# CITY OF ALBUQUERQUE

October 29, 2015

RE: **Starbucks**  
**4301 San Mateo Blvd. NE**  
**Request Permanent C.O. – Not Accepted**  
**Engineers Stamp Date 2/9/15 (G17D006C)**  
**Certification Dated 10/23/15**

SHEET TITLE:
GRADING & DRAINAGE PLAN
AS-BUILT

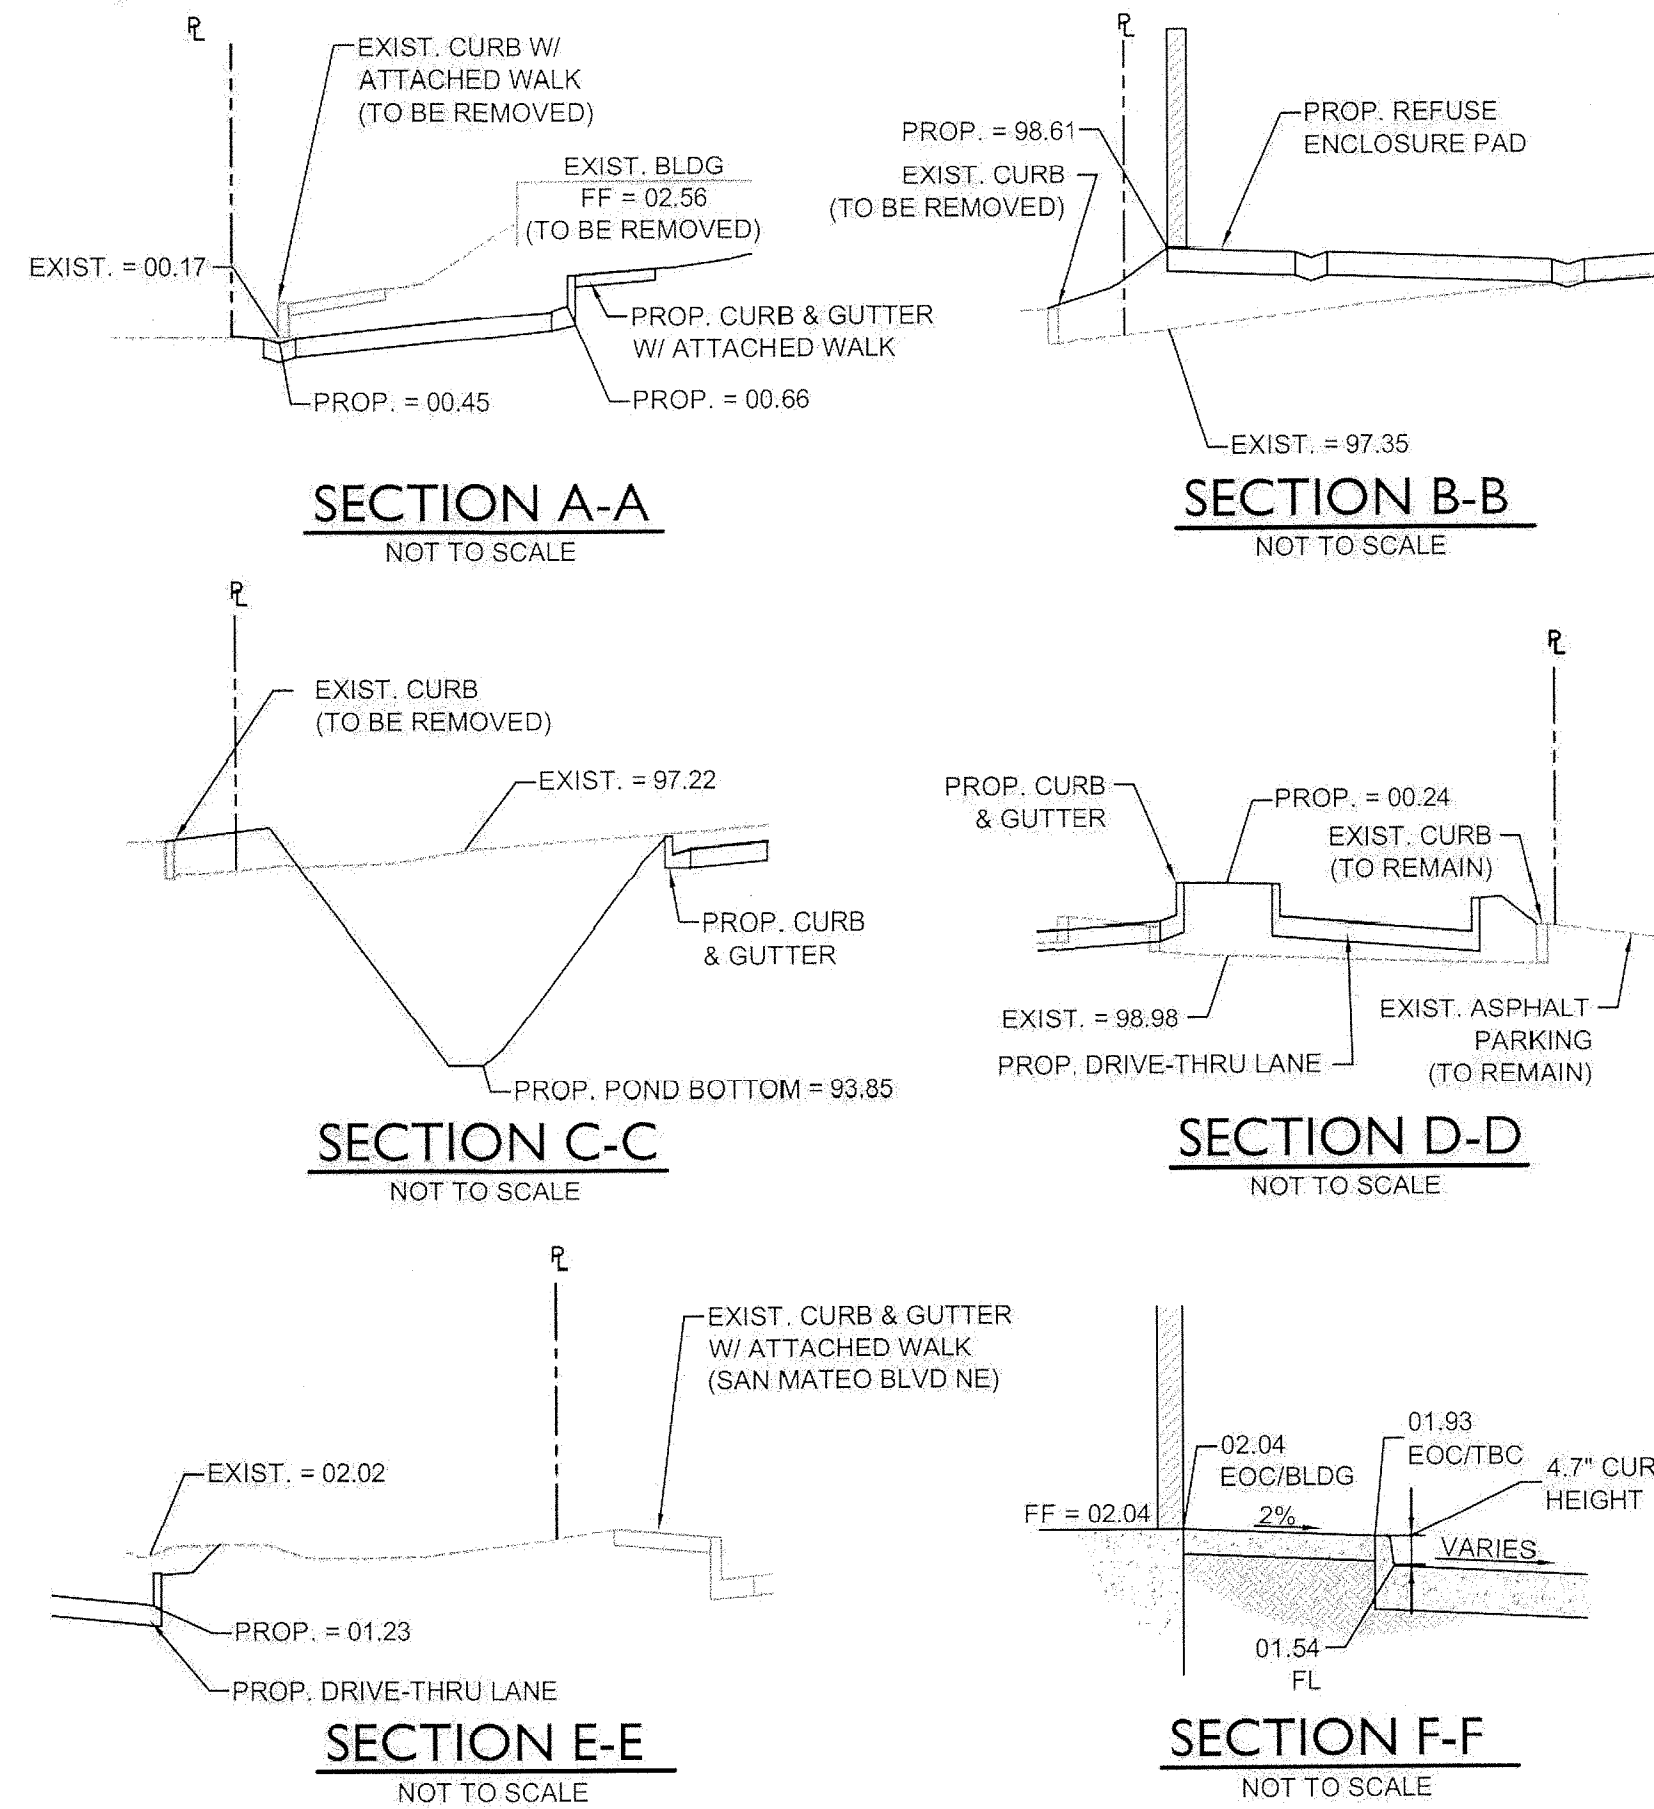
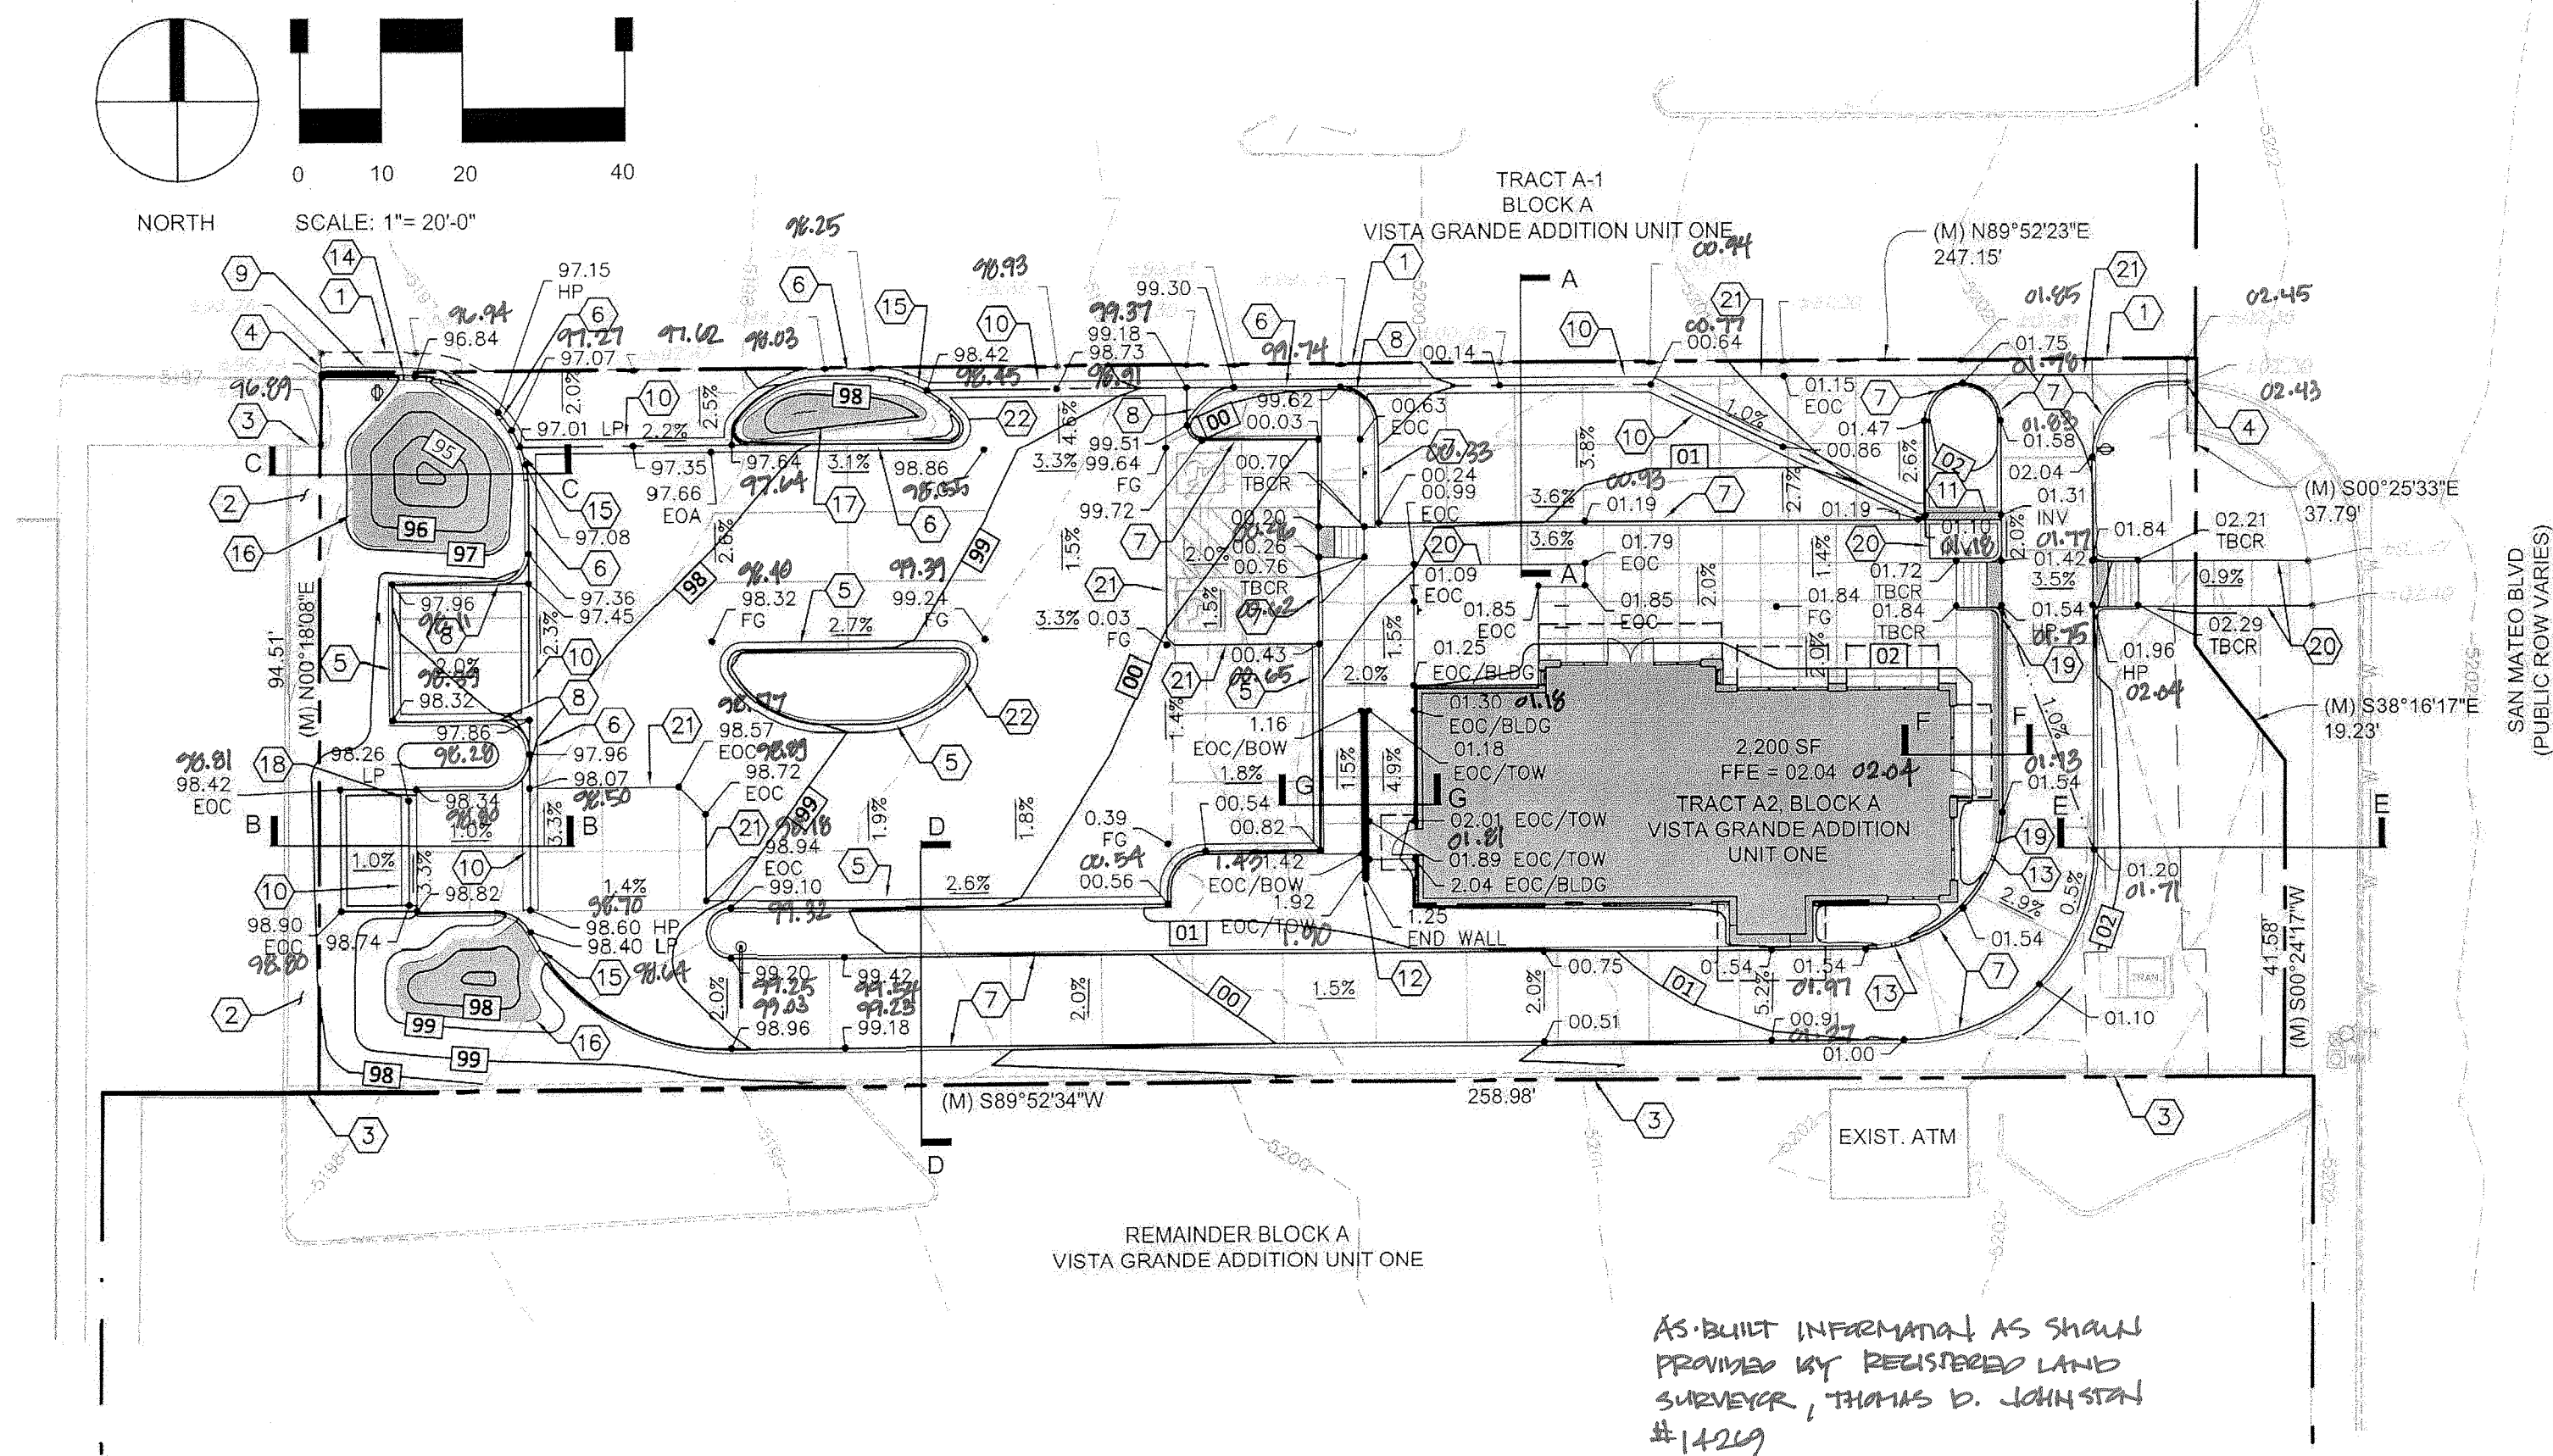
- The concrete sidewalk culvert does not have the steel plate top.
- The 2' wide concrete pan from the concrete sidewalk culvert following thru behind the north parking area is missing.
- The 6" curb opening on the west end of the building is missing.
- Justify this course of action or follow the plan which was approved.
